PRE-LODGEMENT ENGAGEMENT REPORT

State Significant Development Application for a Residential Flat Building with In-fill Affordable Housing

No. 35-39 Darley Street East,
MONA VALE

DATE: 4 June 2026

PLA-DA-10B1

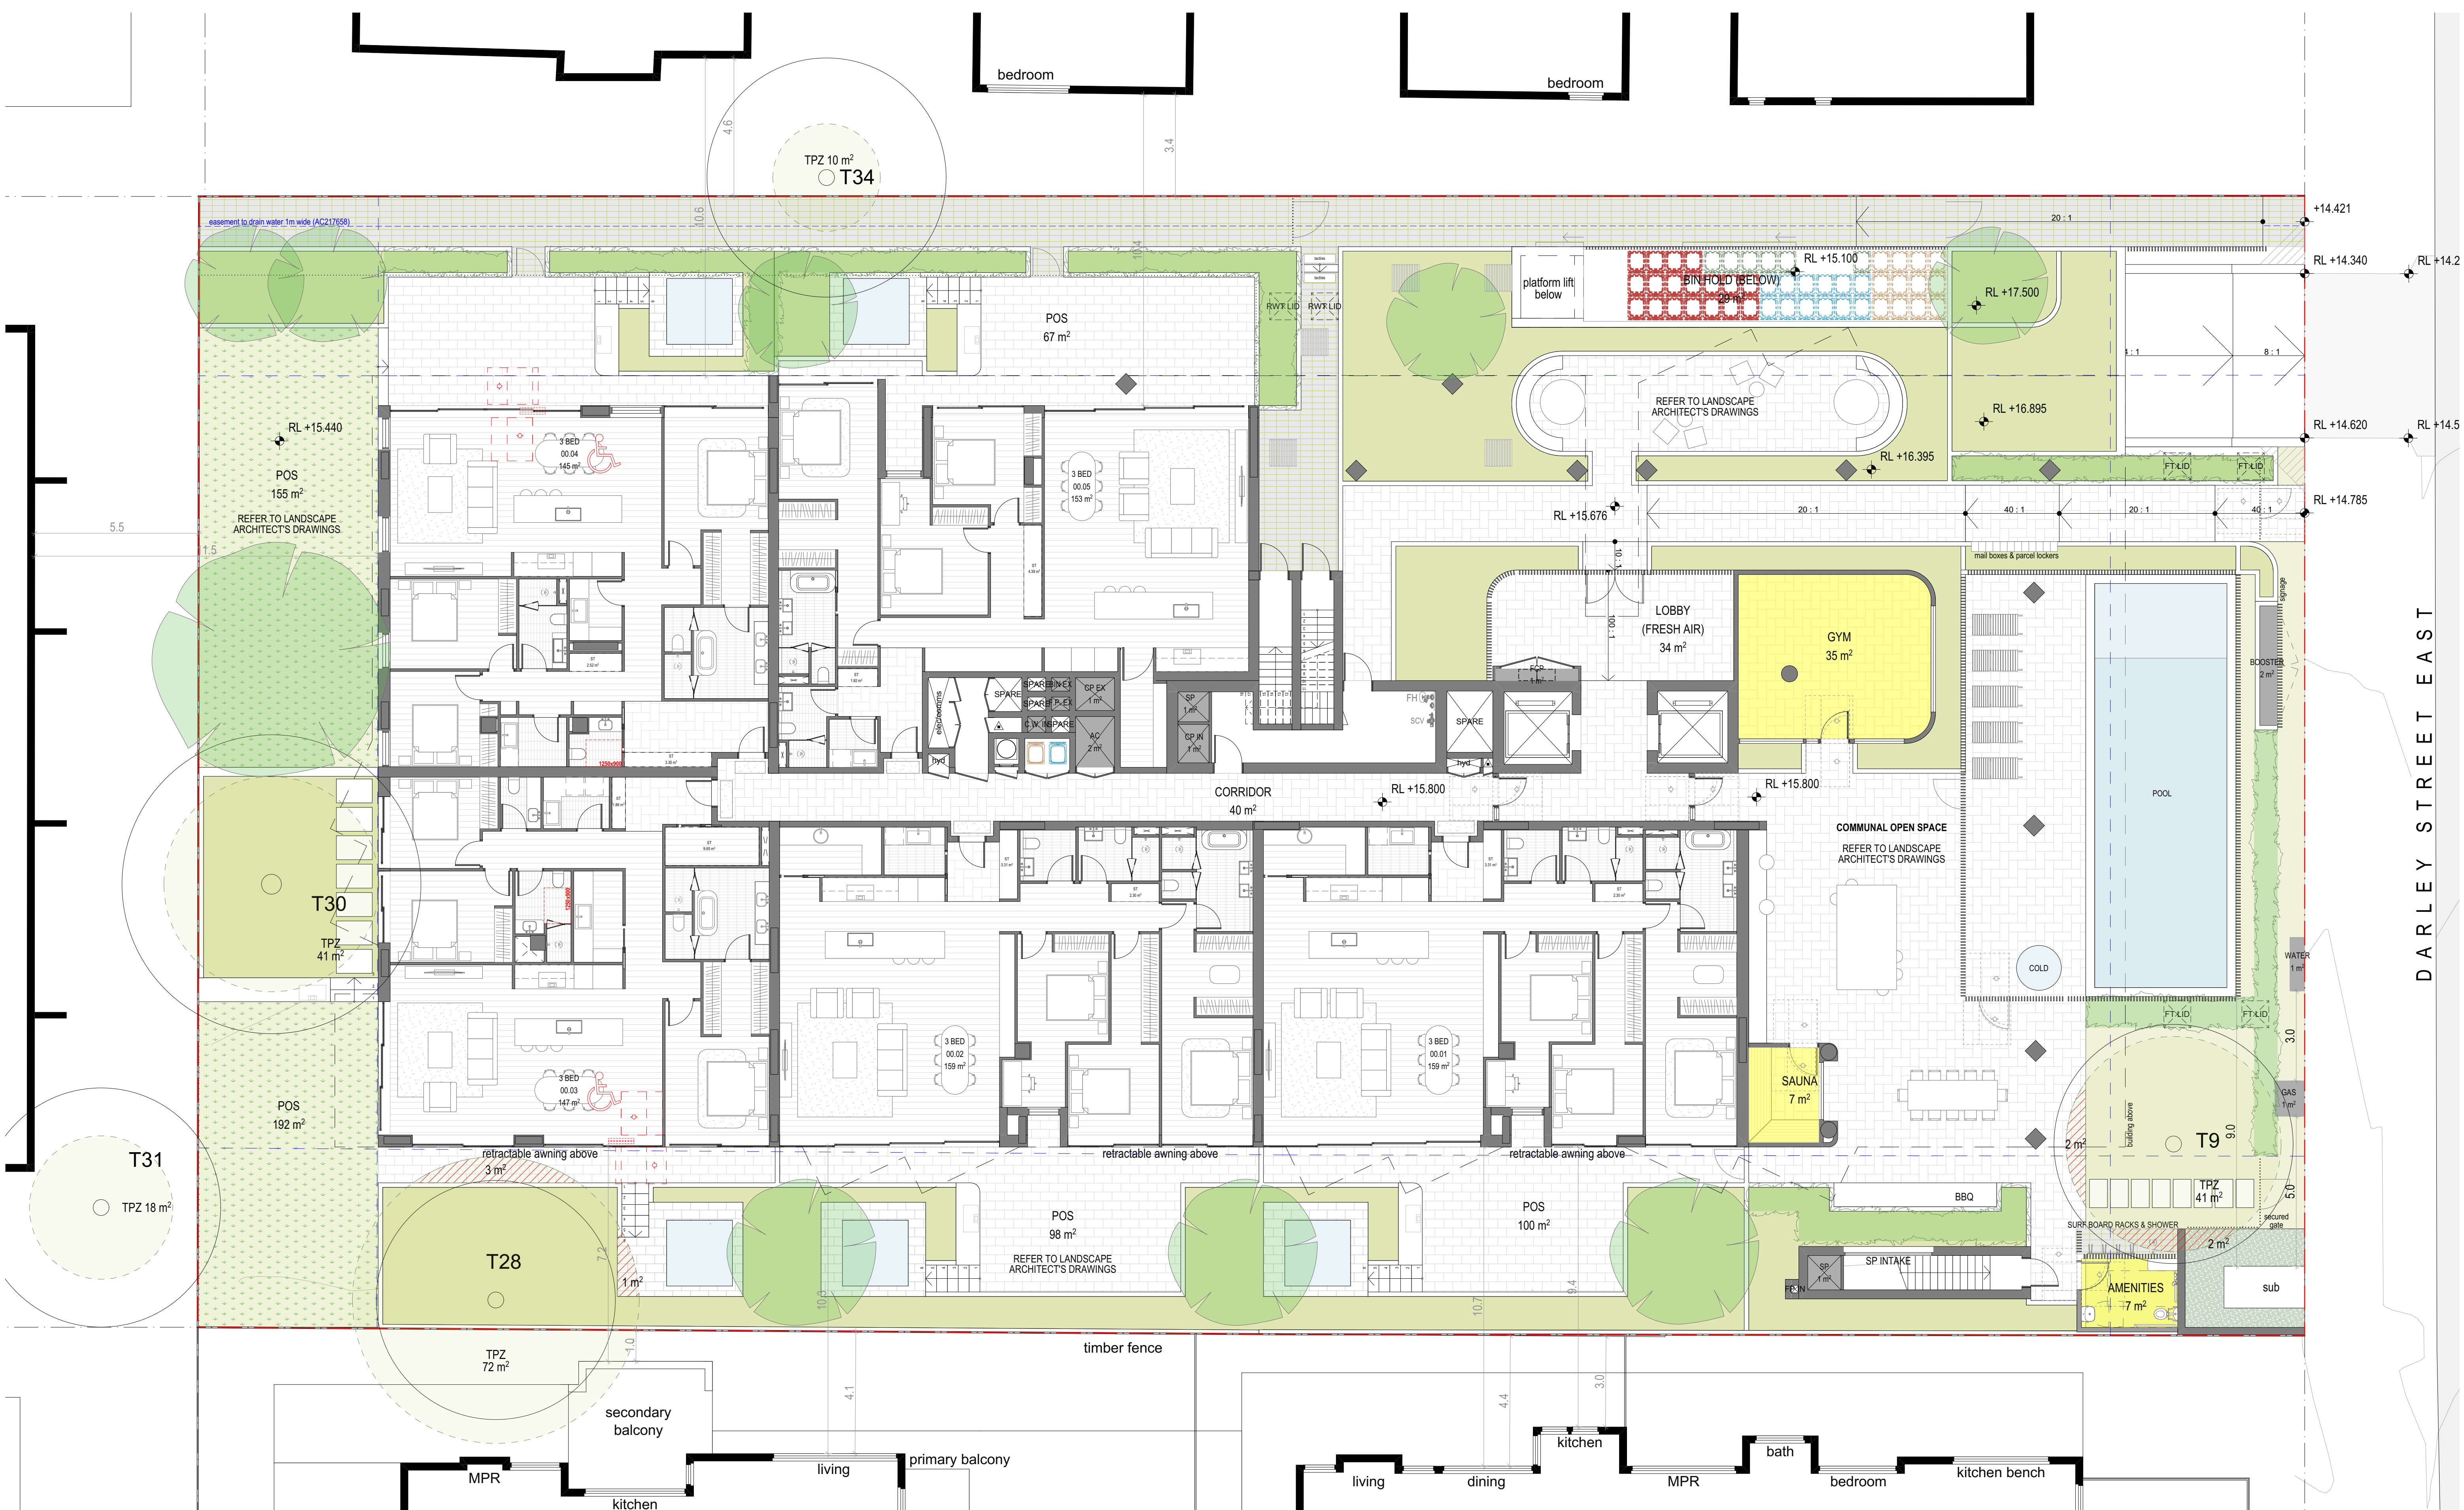
- *Basement access - confirm that the driveway ramp accommodates two-way traffic movement.*

Comment: Swept paths are indicated on the basement floor plan Drawing Number PLA-DA-10B1 and demonstrate two way movement of vehicles can be achieved.
